Your Ref: OWPC16913
Our Ref: LU/427/17/PL 21-12-2017
Please ask for:
Ross Leal

Siting of lodge style building for site office & security (resubmission following LU/141/16/PL). This application is a Departure from the Development Plan.

Castlevew Nursery Old Mead Road Littlehampton

BLOCK 1:500

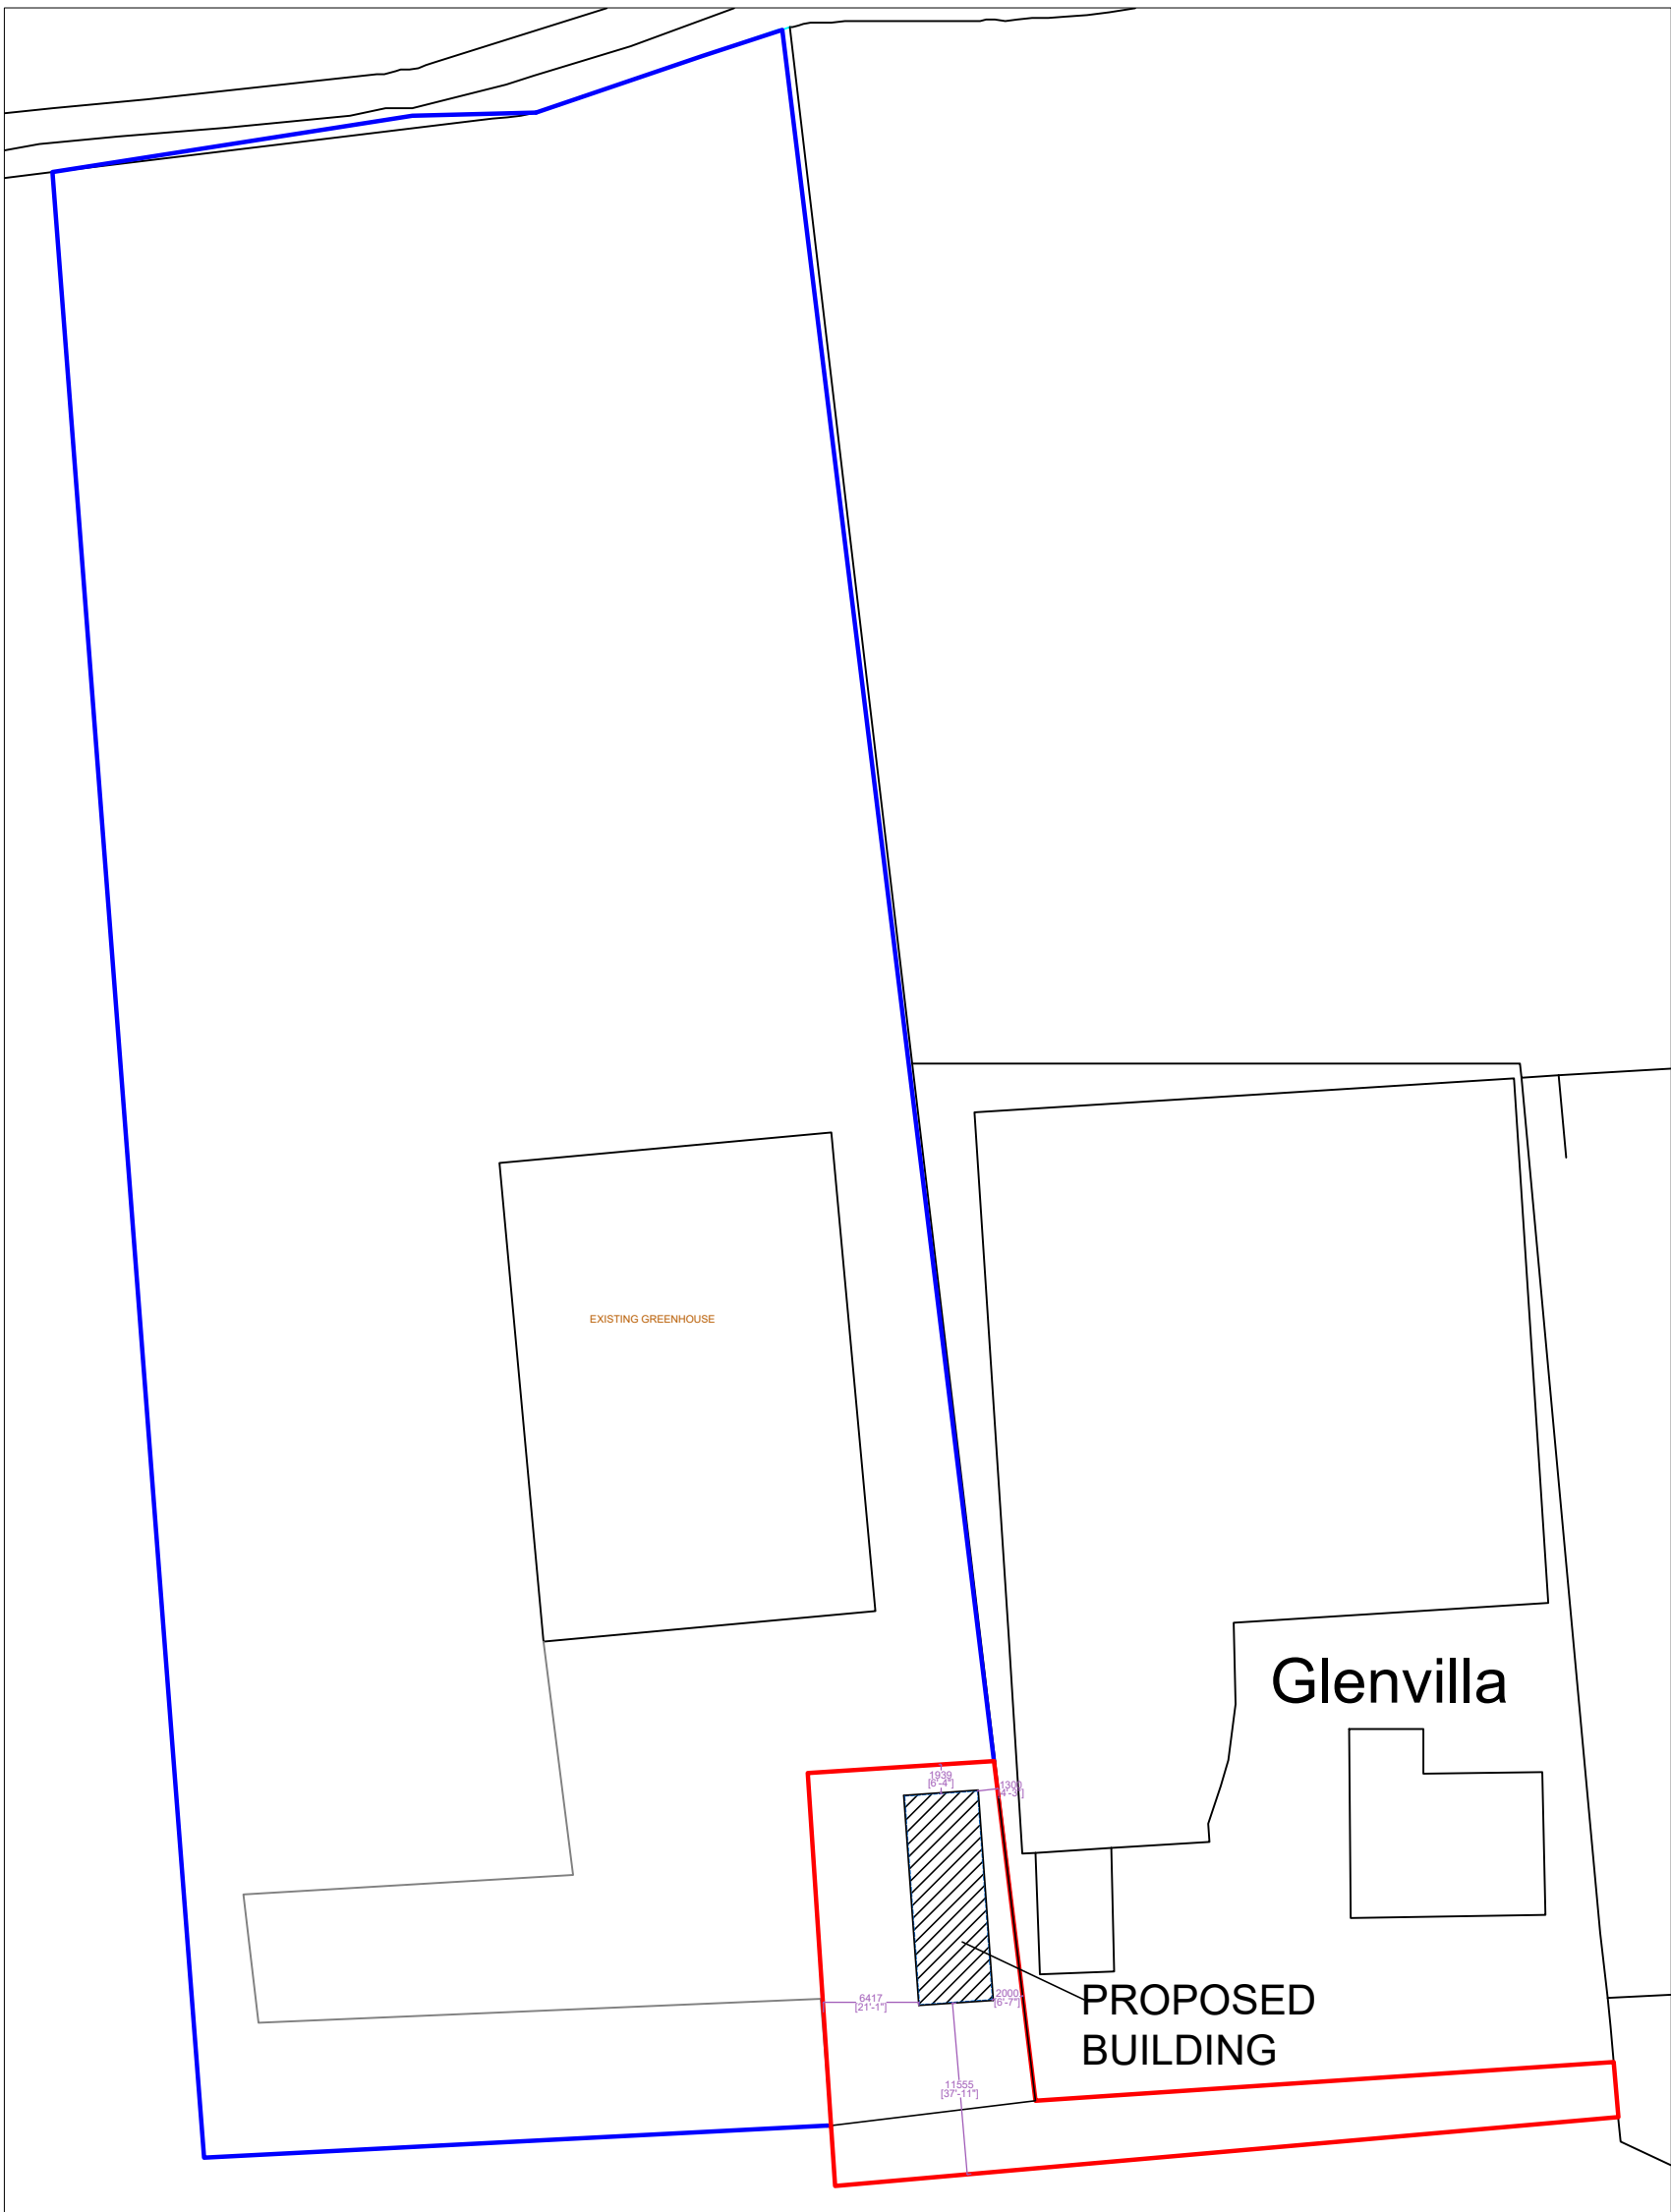
It states on the planning application that this buildings sewerage and waste water will be drained into a cesspit. However there is no plan showing where the cesspit will be located and being on a former landfill site how this will be achieved. In his former application there was going to be a septic tank installed has this changed or has the septic tank already been installed with all the necessary building regulations complied with and the necessary licences from the Environment Agency. As this is a sensitive area with the added boreholes close by everything needs to be consulted with the Environment Agency, also the surface water drainage needs to be considered very carefully to ensure that it does not drain onto my property which extends to 2.1/2 acres on his eastern boundary.
